CITY OF ALBUQUERQUE

October 6, 2014

**RE: Cuatro Development
Erosion and Sediment Control (ESC) Plan (J14E173)
Engineers Stamp Dates 9-17-14**

EROSION CONTROL PLAN

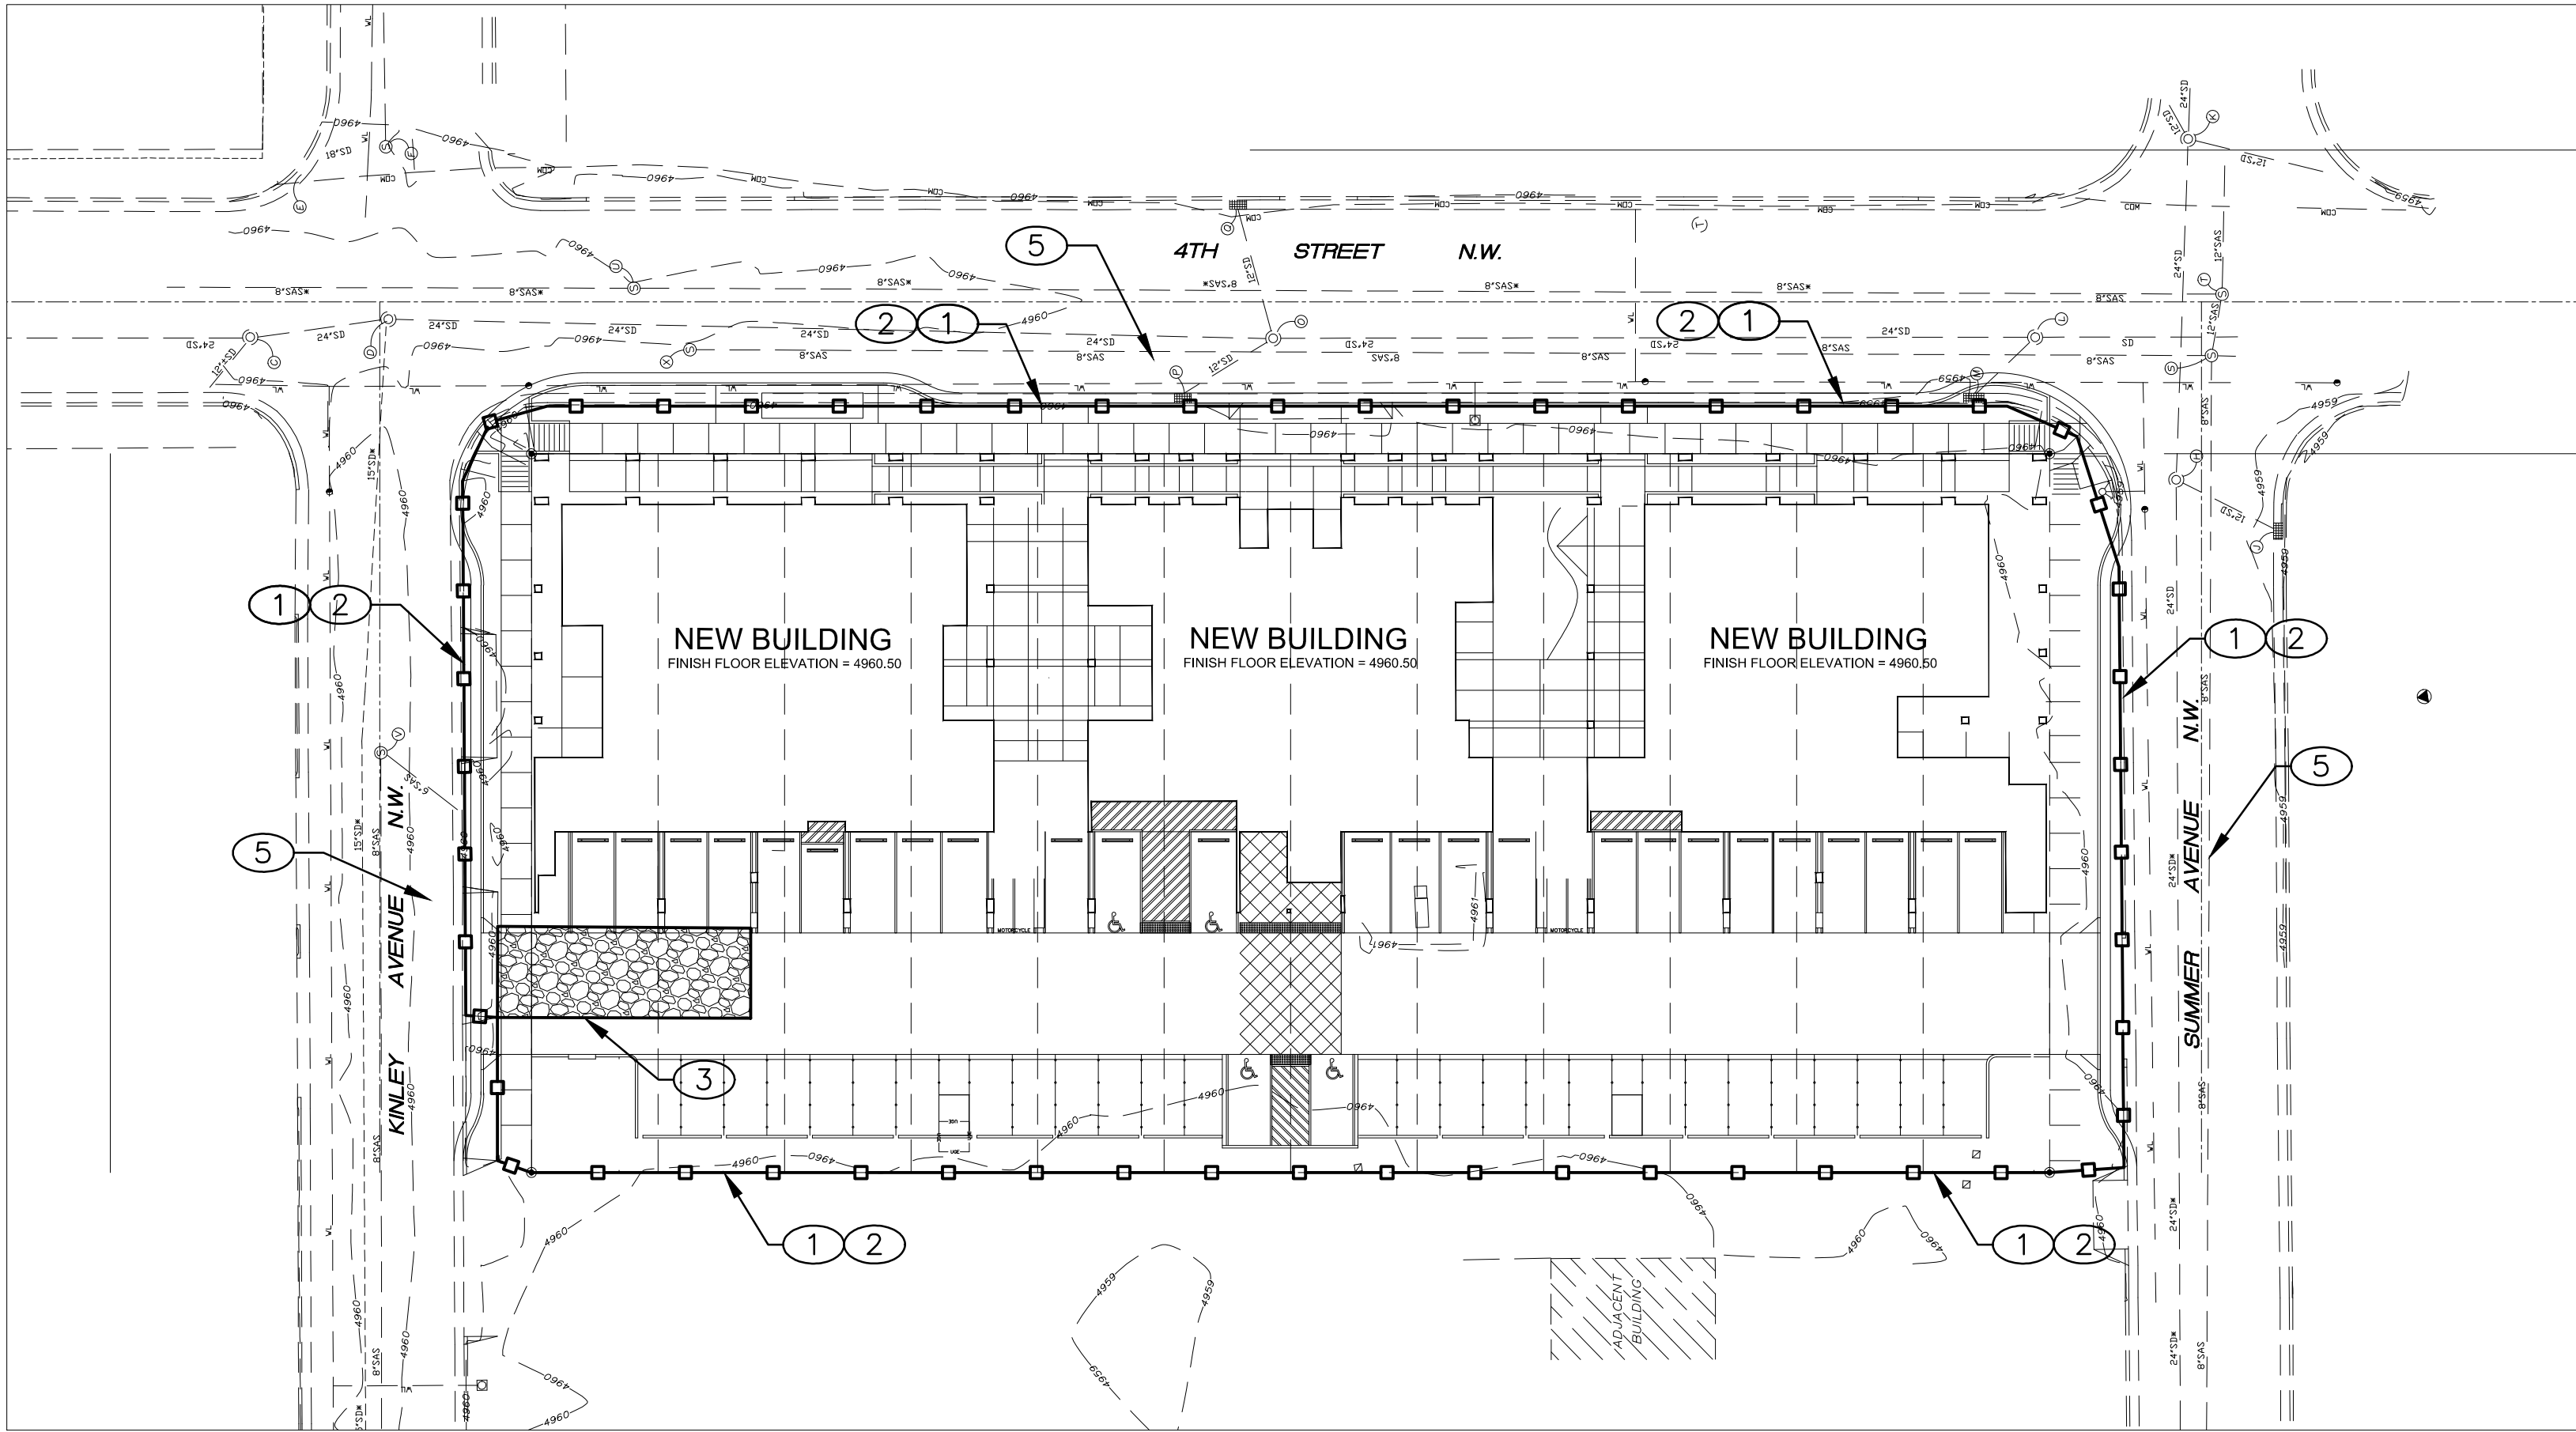
PO Box 1293 _ Include NPDES Posting Board. Posting Board should be visible from Public Street.
